Please ask for: Ms Iqraa Malik
Email: iqraa.malik@terraquest.co.uk
Telephone: 01212341390
Our Ref: WA/44/21/HH
Your Ref:
Date: 21st May 2021

Application for Planning Permission for Works or Extension to a Dwelling

Development: Single storey rear kitchen extension with associated internal alterations with accessible terrace above; single storey side extension with associated internal alterations. Amendments to hard and soft landscaping.
Location: Folie House Wandleys Lane Walberton BN18 0QR

Site Location Plan

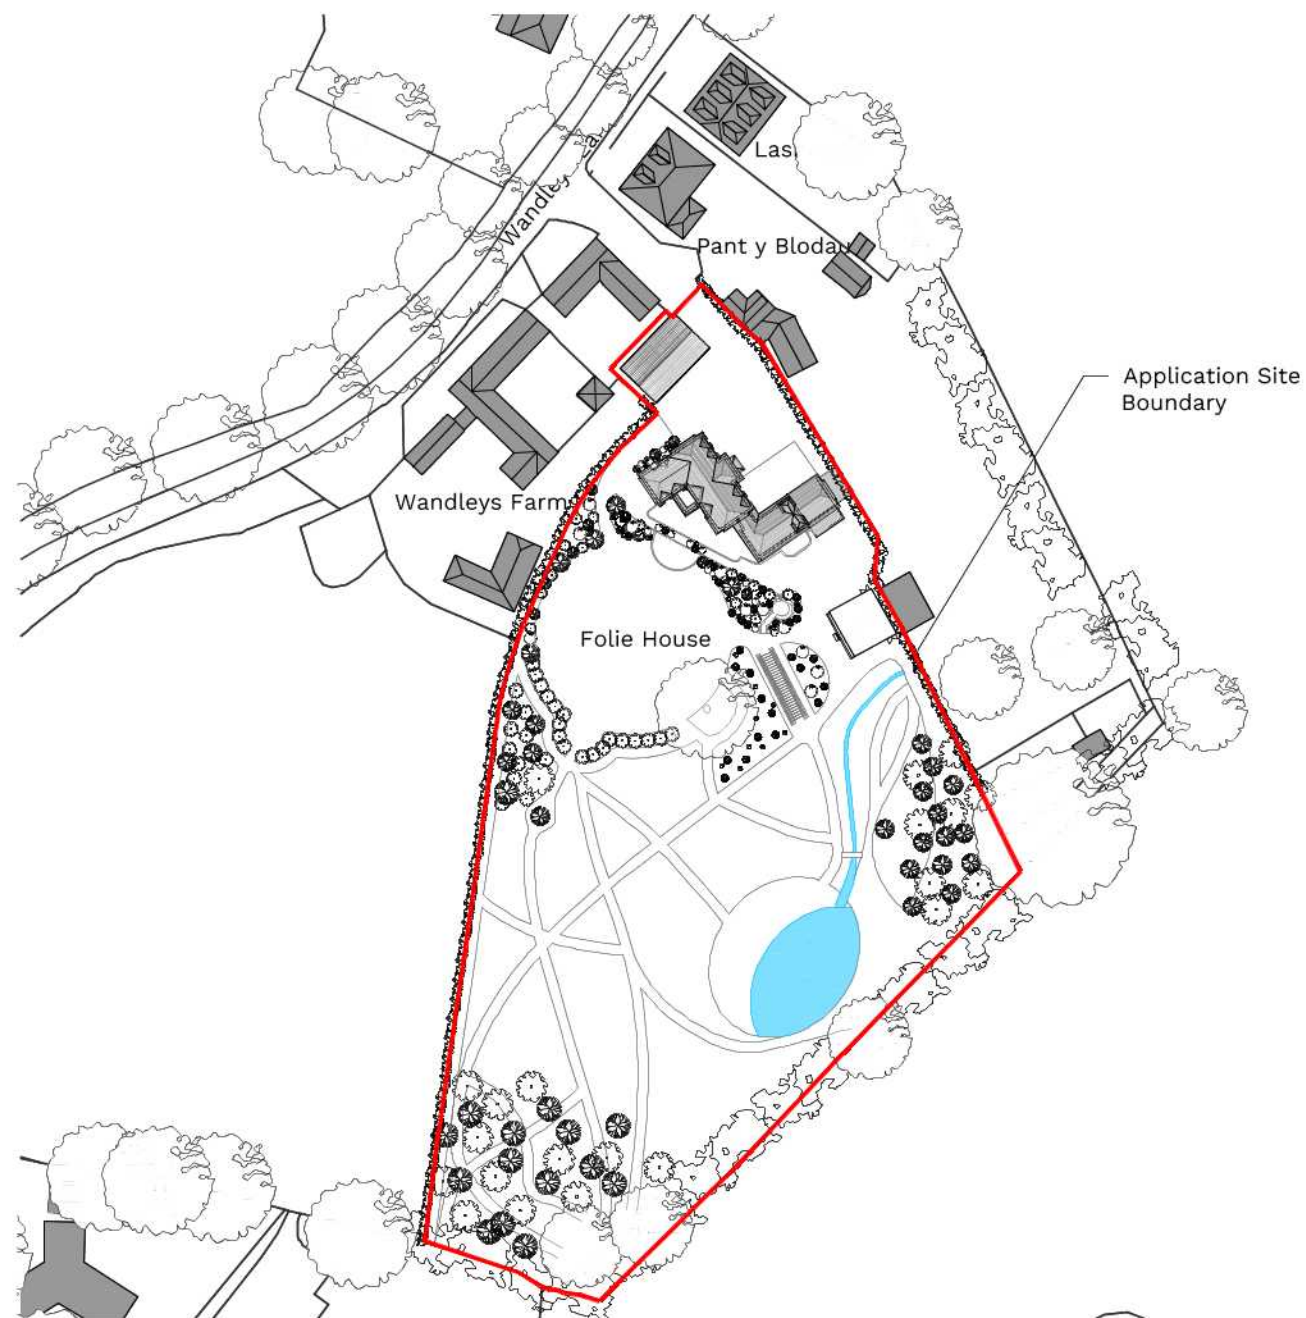
The location plan requires a solid red outline around the site boundary, please amend. Further details of what must be included on the plan can be found in the Validation Requirements List.
